# CITY OF ALBUQUERQUE

May 20, 2016

Re: Trapnell Orthodontics

Grading and Drainage Plan

Drawing file: FINAL / 2053 Trapnell Orthodonitcs CG-101 AND CG-501 SIGNED 11-25-14.pdf

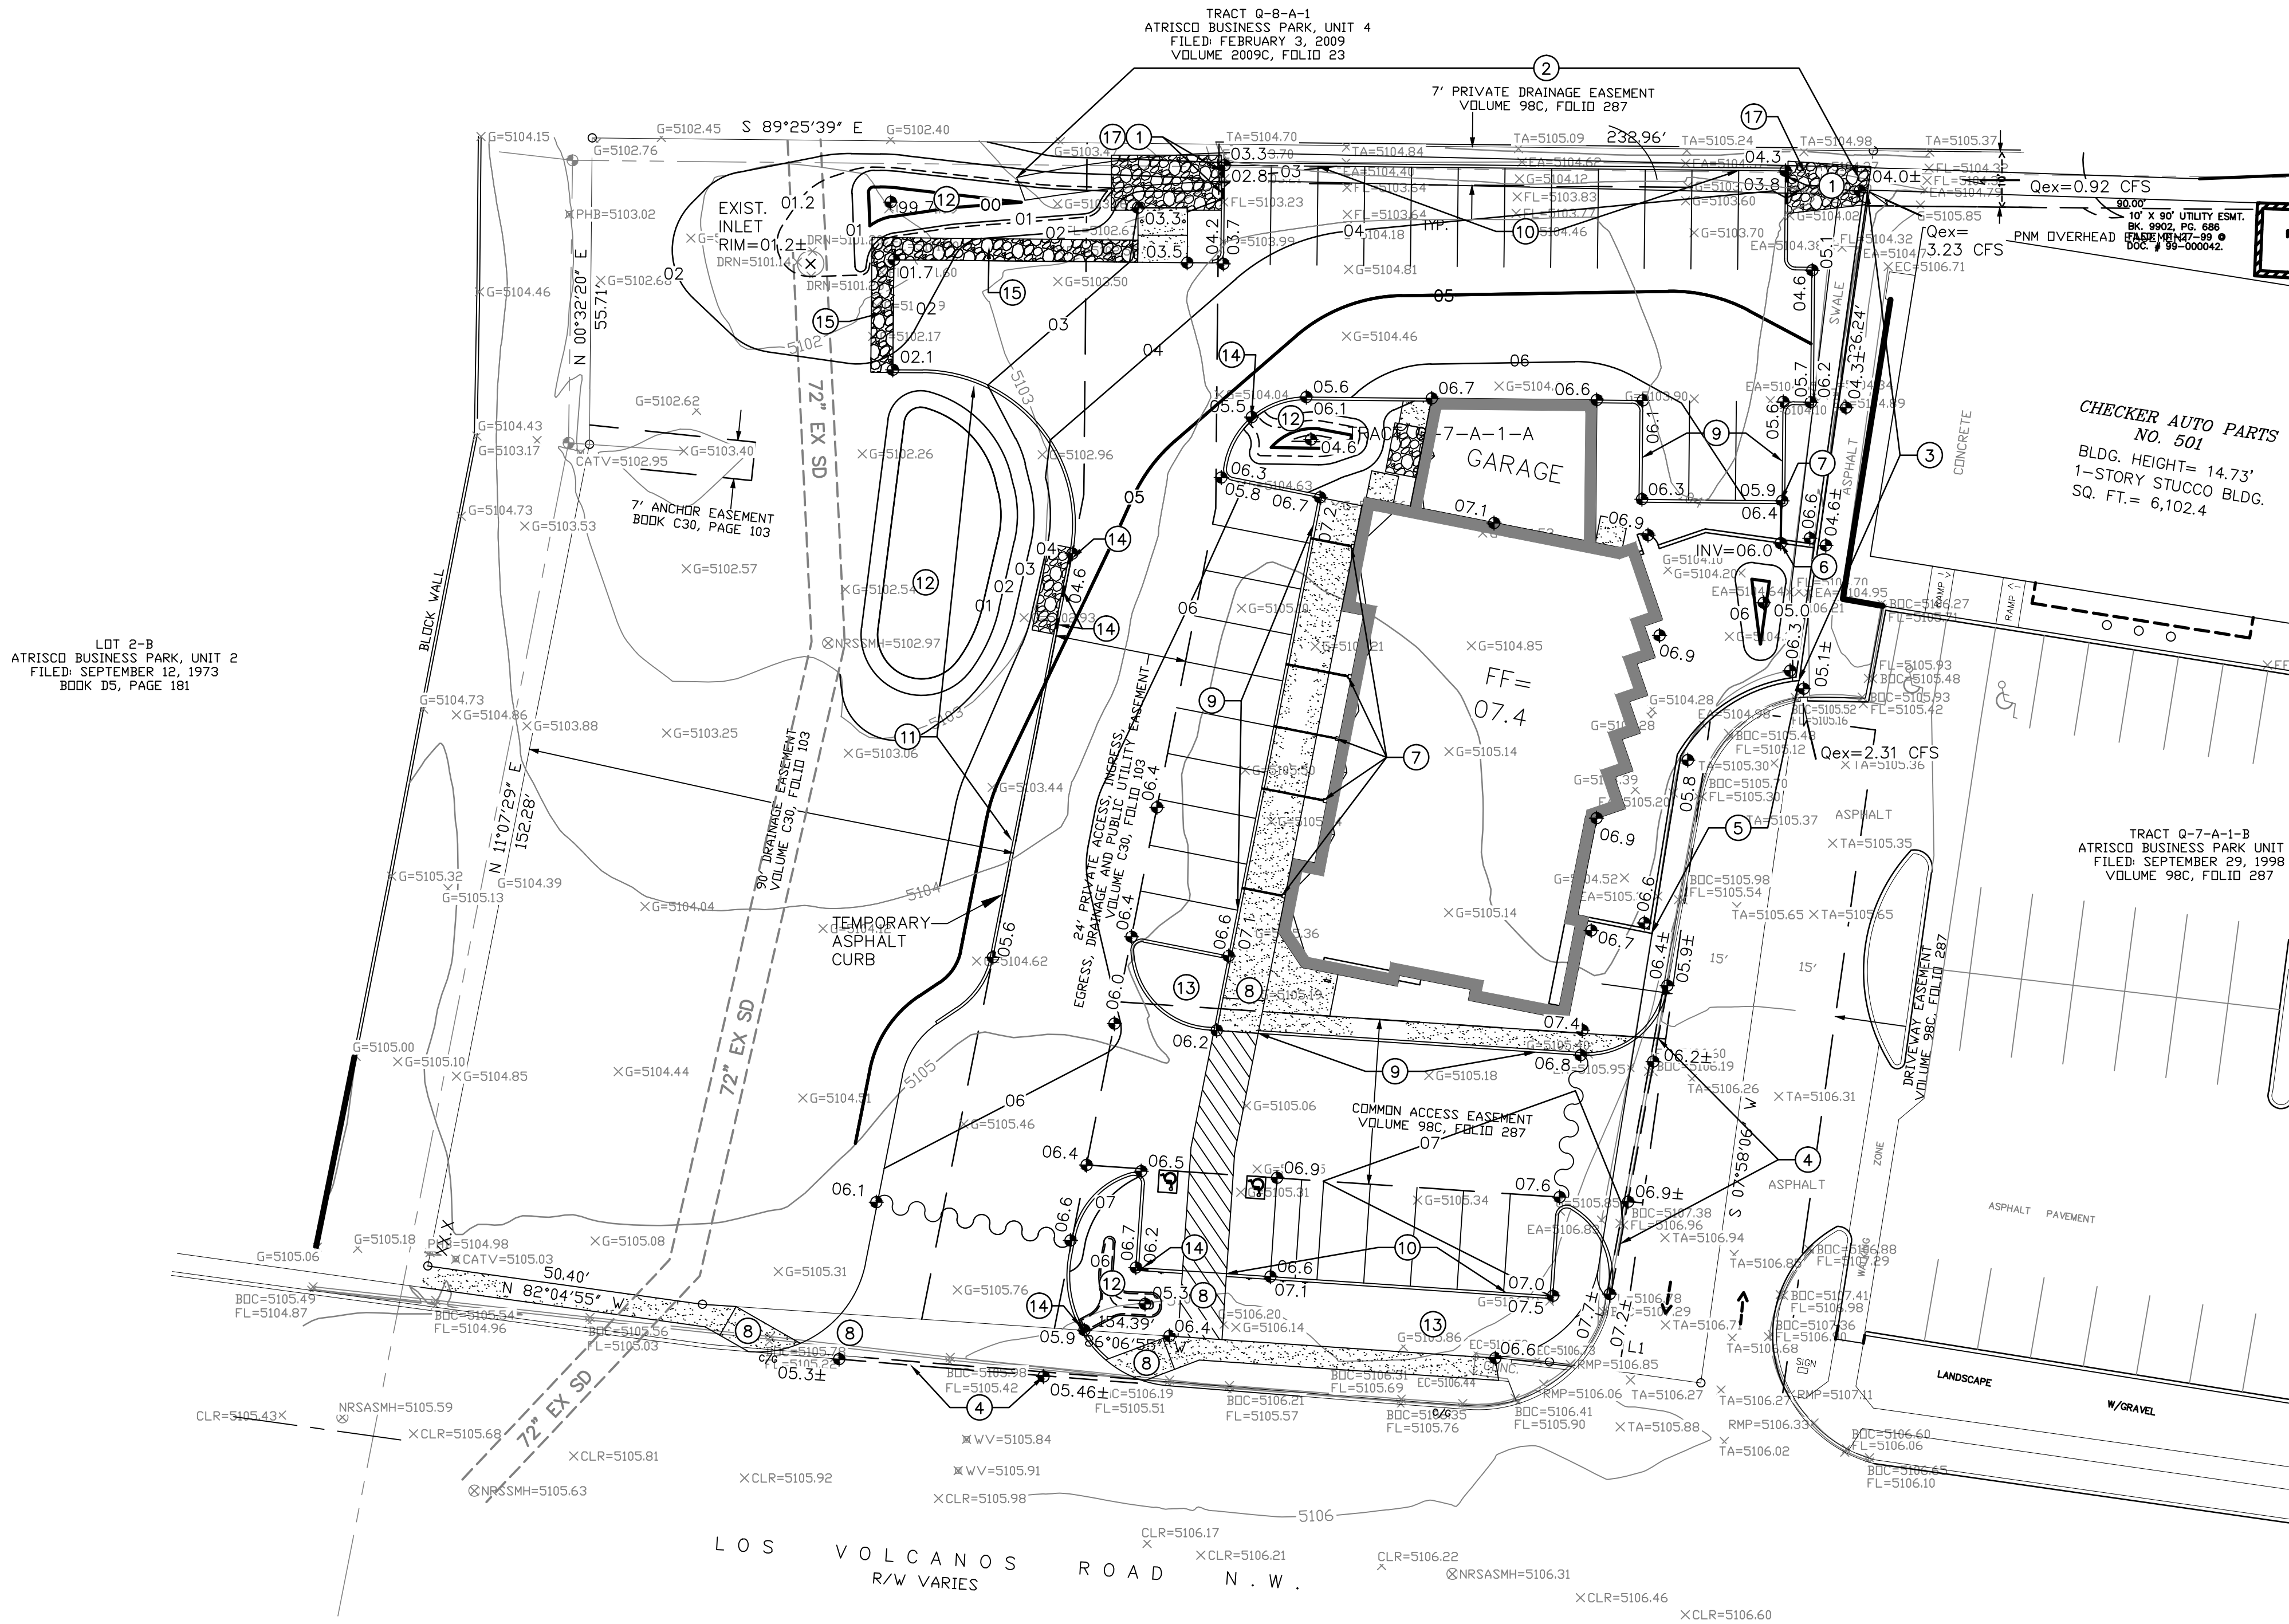
I visited the site this AM and I have one question. Note #5 states that the retaining wall is to have vertical gaps along the row of blocks at the top earth grade. These openings are missing. Will the site drain sufficiently without these openings?

I hadn't thought to look at those. Good catch. Because of the final landscaping in the courtyard and the fact that it's only water that falls in the courtyard that affects the ponding back there, I don't think it'll be a problem for flooding of the building.

Holes to relieve hydrostatic pressure behind retaining walls are always a good idea, though. I'll ask the contractor to put a few 4" PVC pipes through the wall.
